**Re: Hogares Charter School, 4903 4th Street NW, Grading and Drainage Plan
Engineer's Stamp dated 11-19-04 (F14-D59)**

Re: Hogares Charter School, 4903 4th Street, Traffic Circulation Layout
Engineer's Stamp dated 11-19-04 (F14-D59)

**Re: Hogares Charter School, 4903 4th Street, Traffic Circulation Layout
Engineer's Stamp dated 11-19-04 (F14-D59)**

SHEET NO.
 TCL

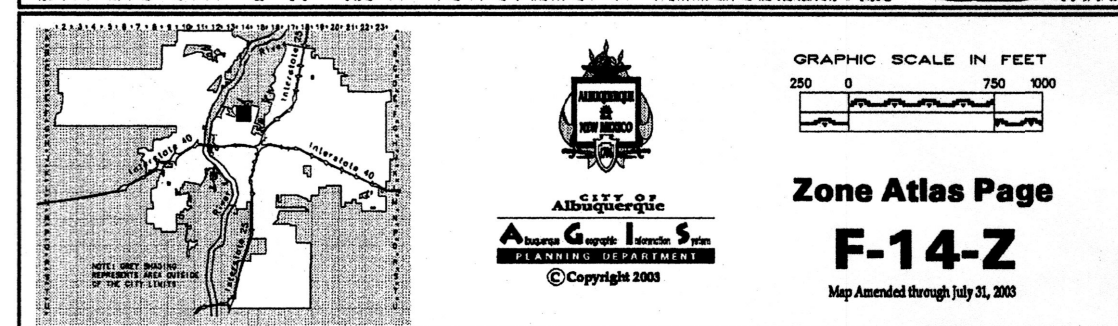
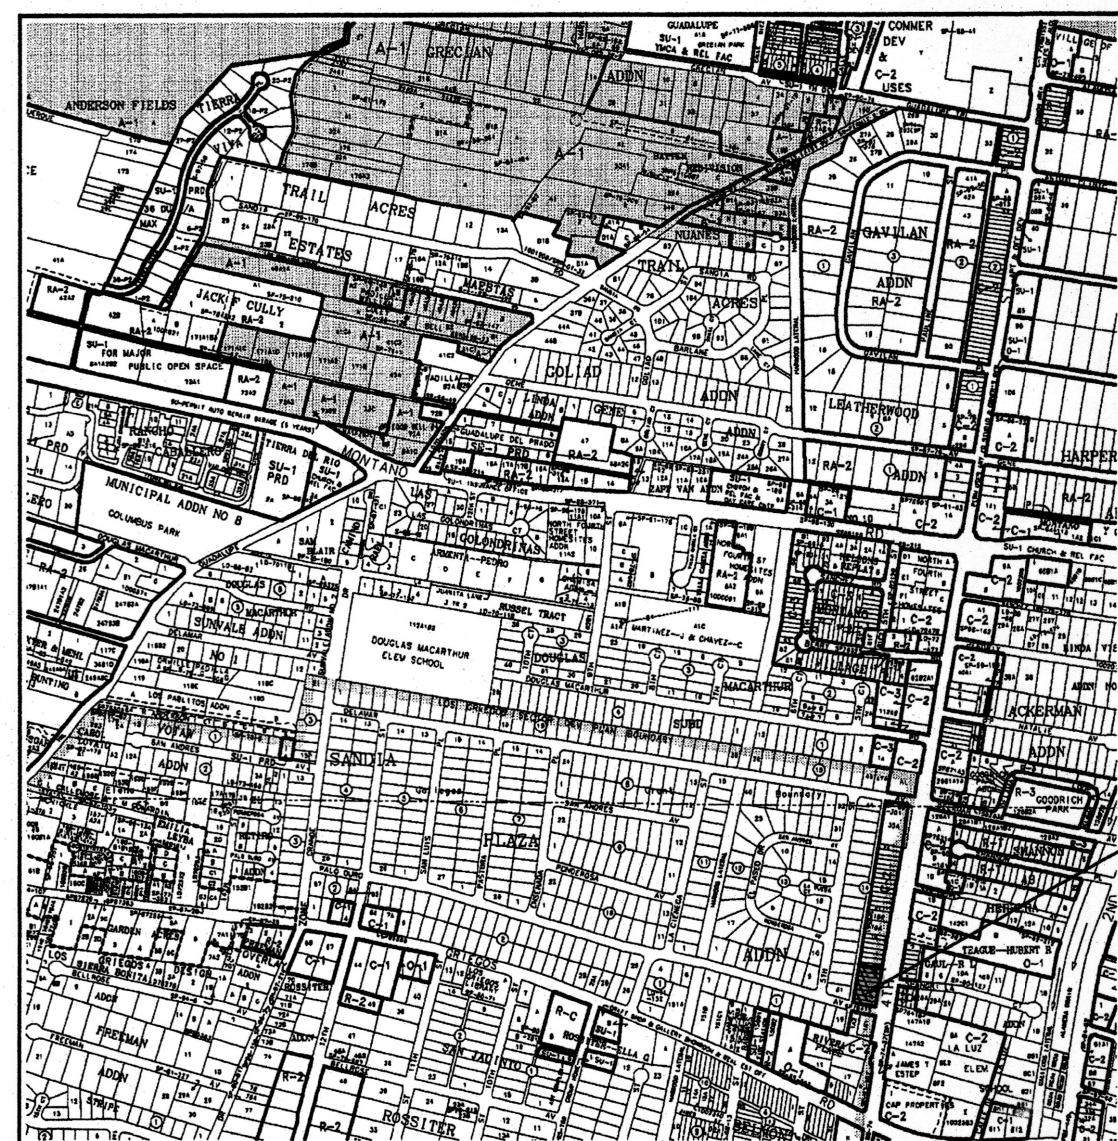
1. Please show the specific location of the above referenced site on the vicinity map.
2. Please list the width and length for all parking spaces.
